ENG-PUDSP22001-R1-GEC.pdf Markup Summary

PUDSP221

**POND G**  
**WQ POND**  
**OUTLET STRUCTURE DETAILS**

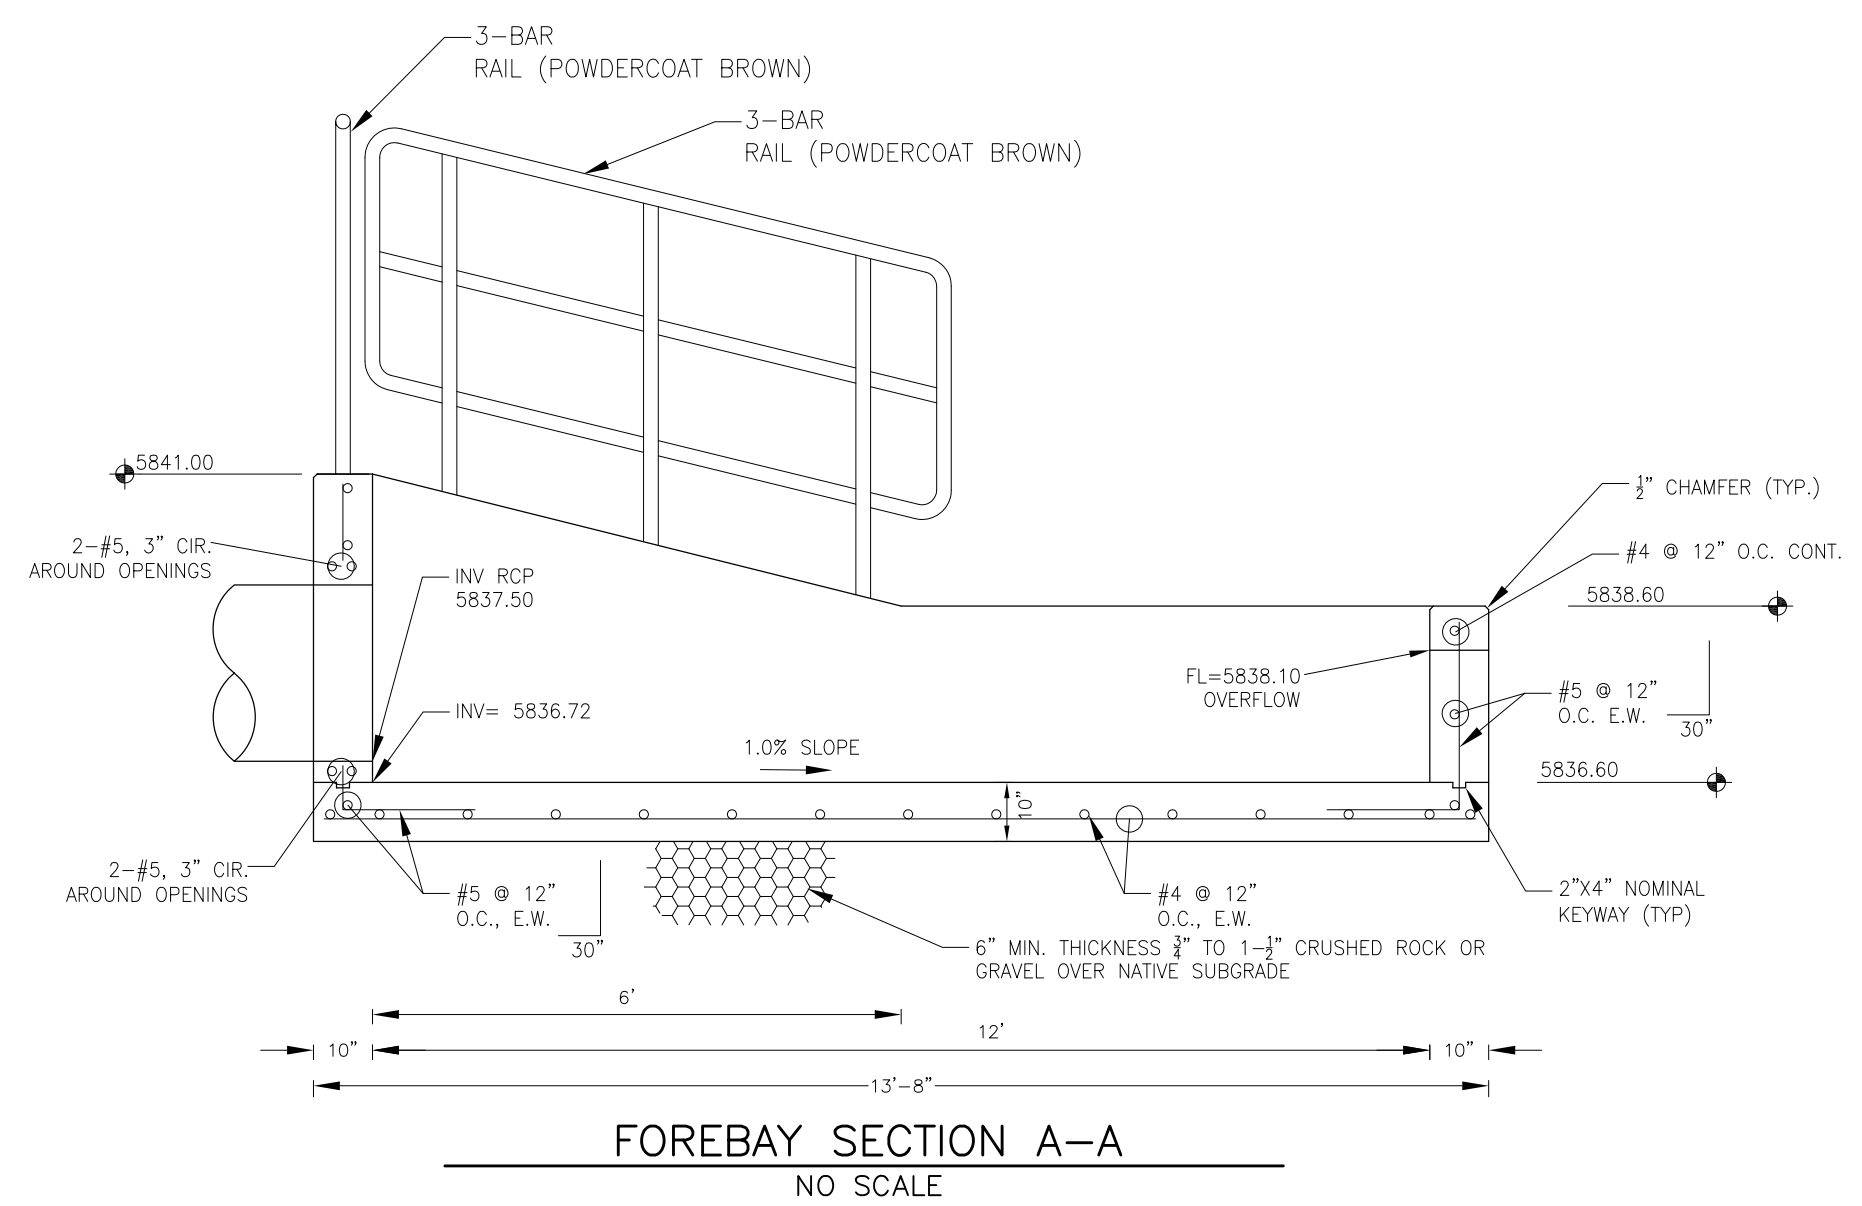
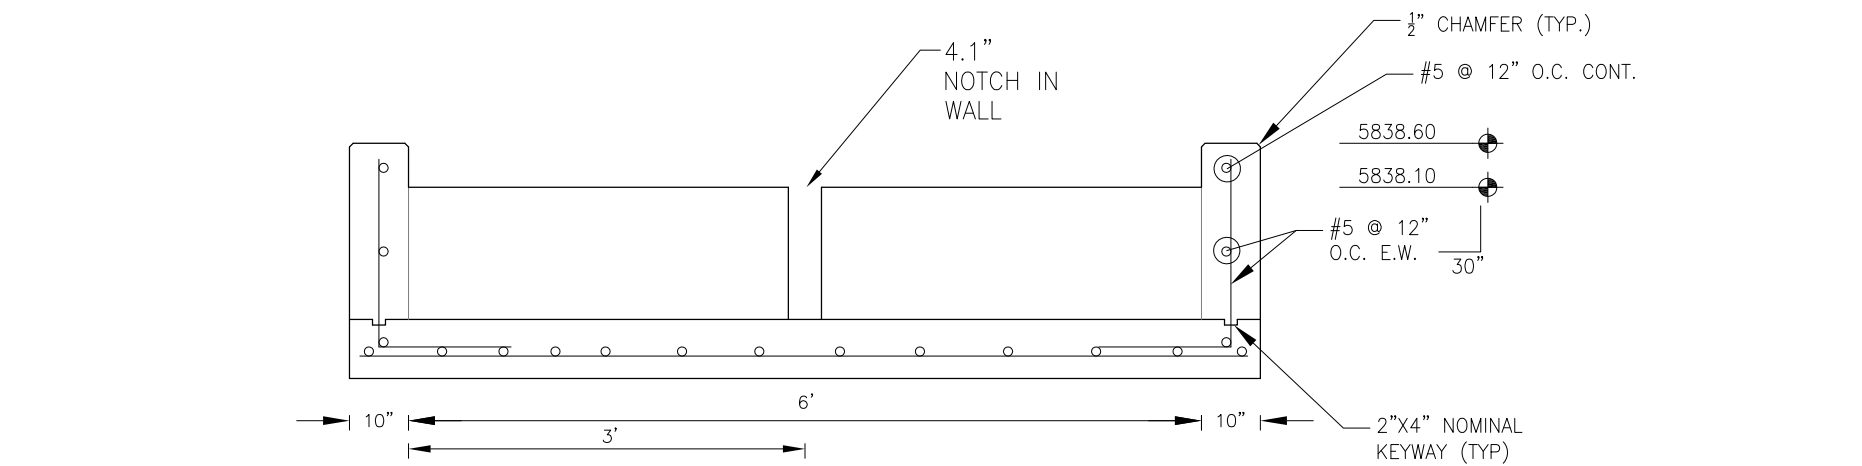
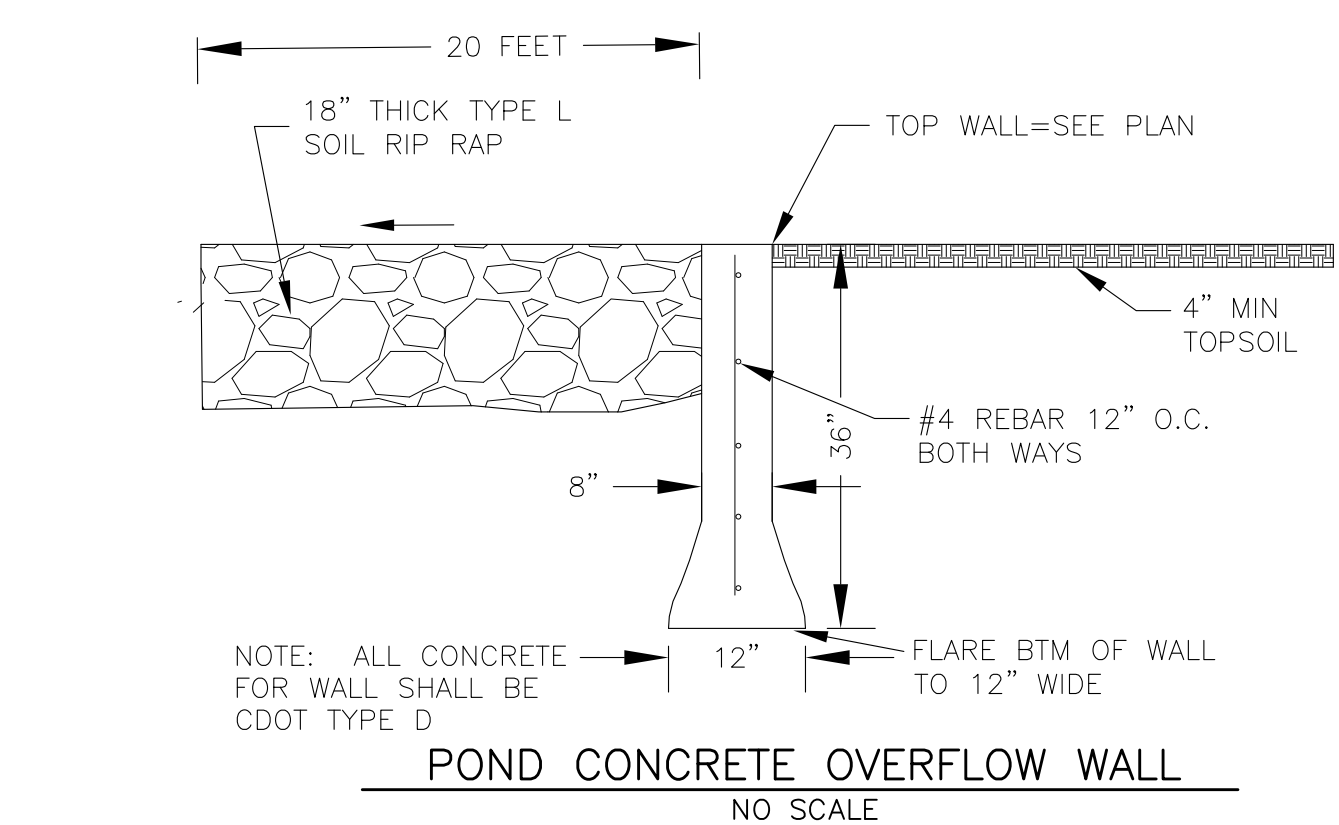
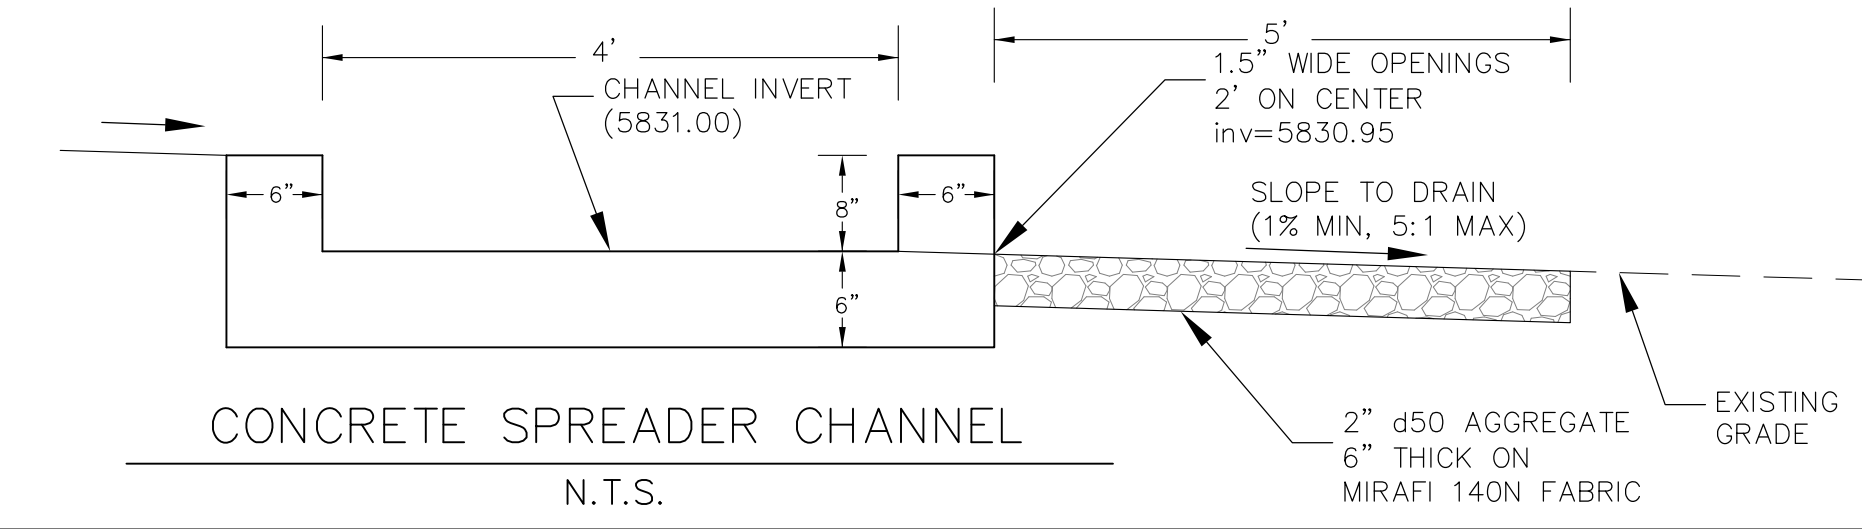
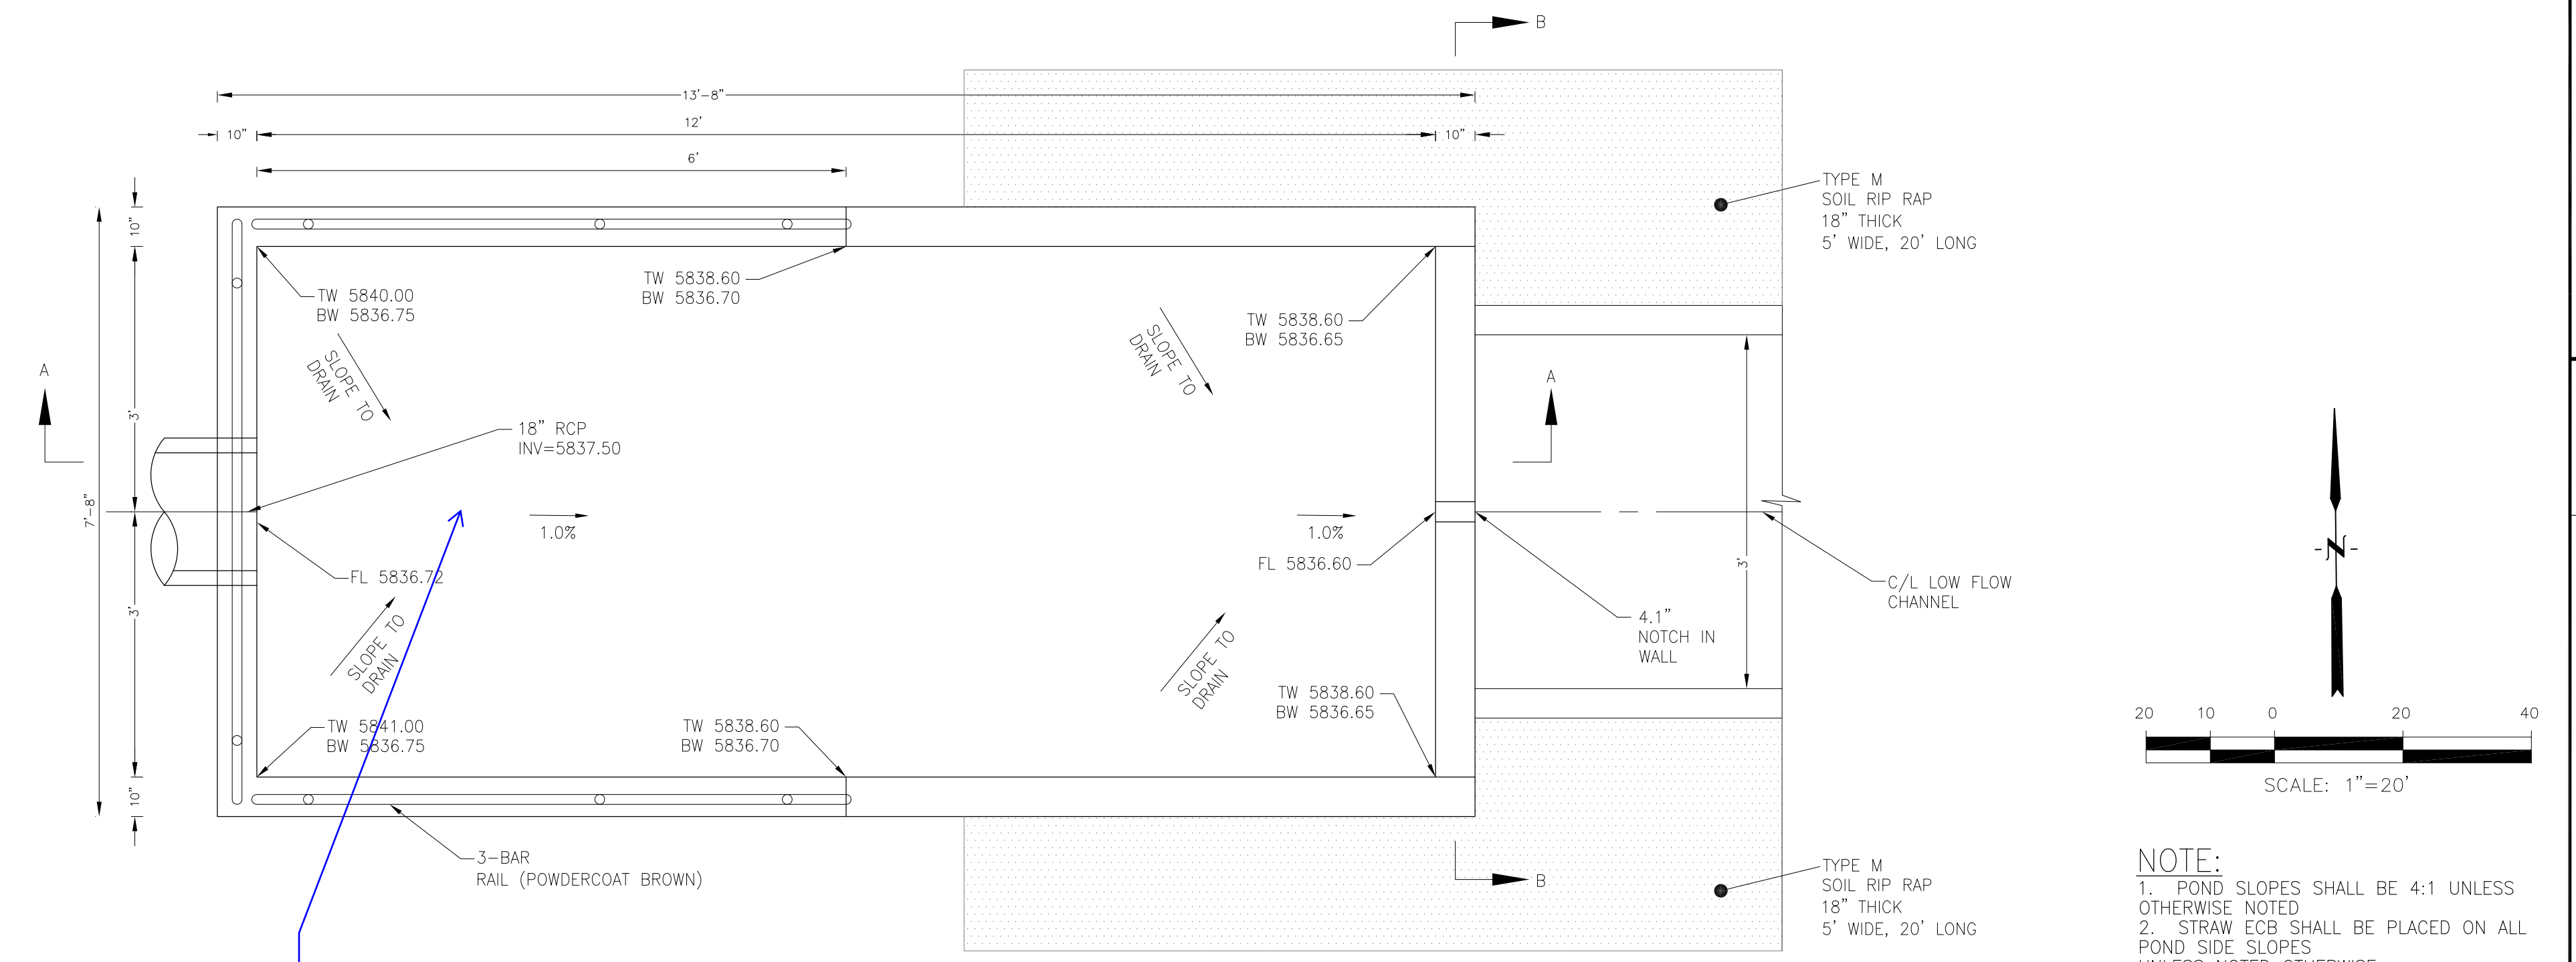
PDR pg 110 shows a Type C grate. Revise to remove discrepancy.

provide detail with LxWxH dimensions and size of riprap.

double check volume calcs. I get 0.0033 ac-ft, whereas pdf pg 125 of PDR states min should be 0.004 ac-ft.

6ft x 12ft x 2ft / 43560 sqft/ac = 0.0033 ac-ft.

Remove "WQ." Per pdf pg 28 of the PDR, this is a full spectrum detention pond, not a WQ Pond.

provide detail with LxWxH dimensions.
